Consultee Comments for Planning Application

1/1152/2020/FUL

Proposal: Proposed extension to residential home to provide additional bed spaces and enlargement to existing kitchen

On Behalf Of: Environmental Protection Officer

Ground Floor Plan 0 1m
1 : 50

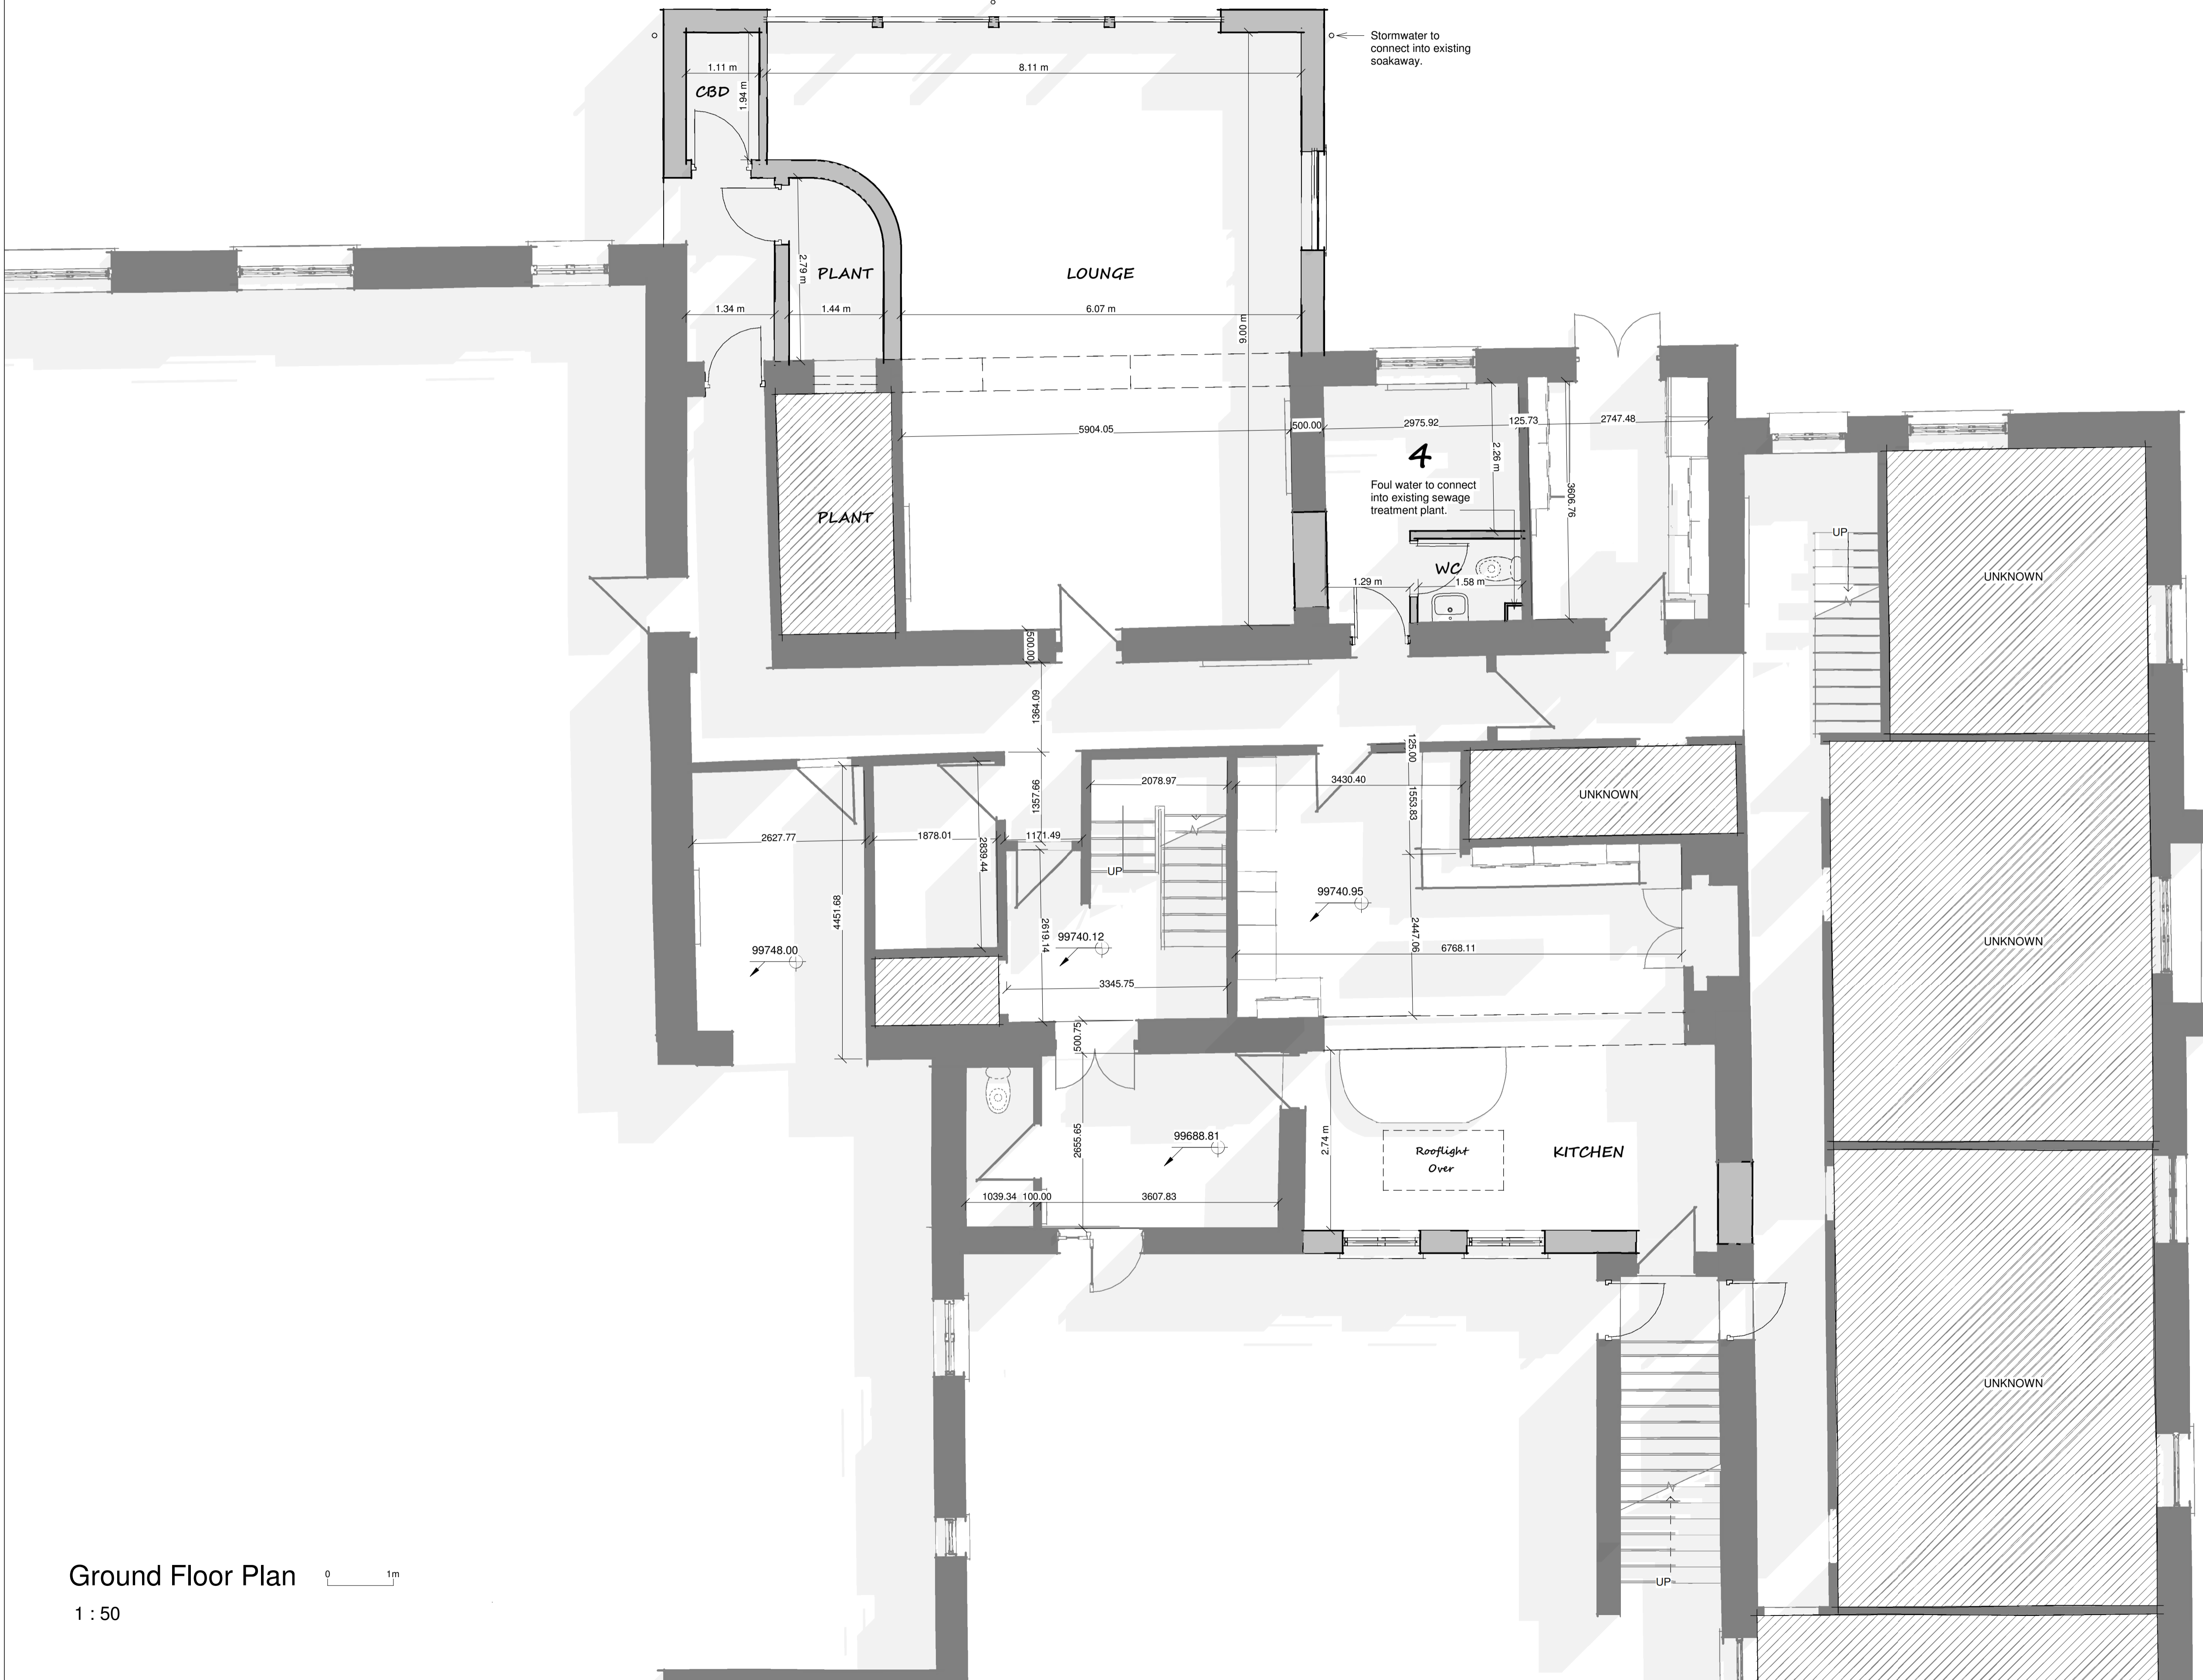
It is noted that the kitchen is located on the western facade and faces a neighbouring property albeit at a reasonable distance. There appears to be no information provided to indicate whether the proposed enlargement of the existing kitchen will involve any changes to or additions in relation to external plant (eg. extraction system). It would be useful to have confirmation of this and if new plant is proposed, further information will be required for review in order to assess any potential impact.
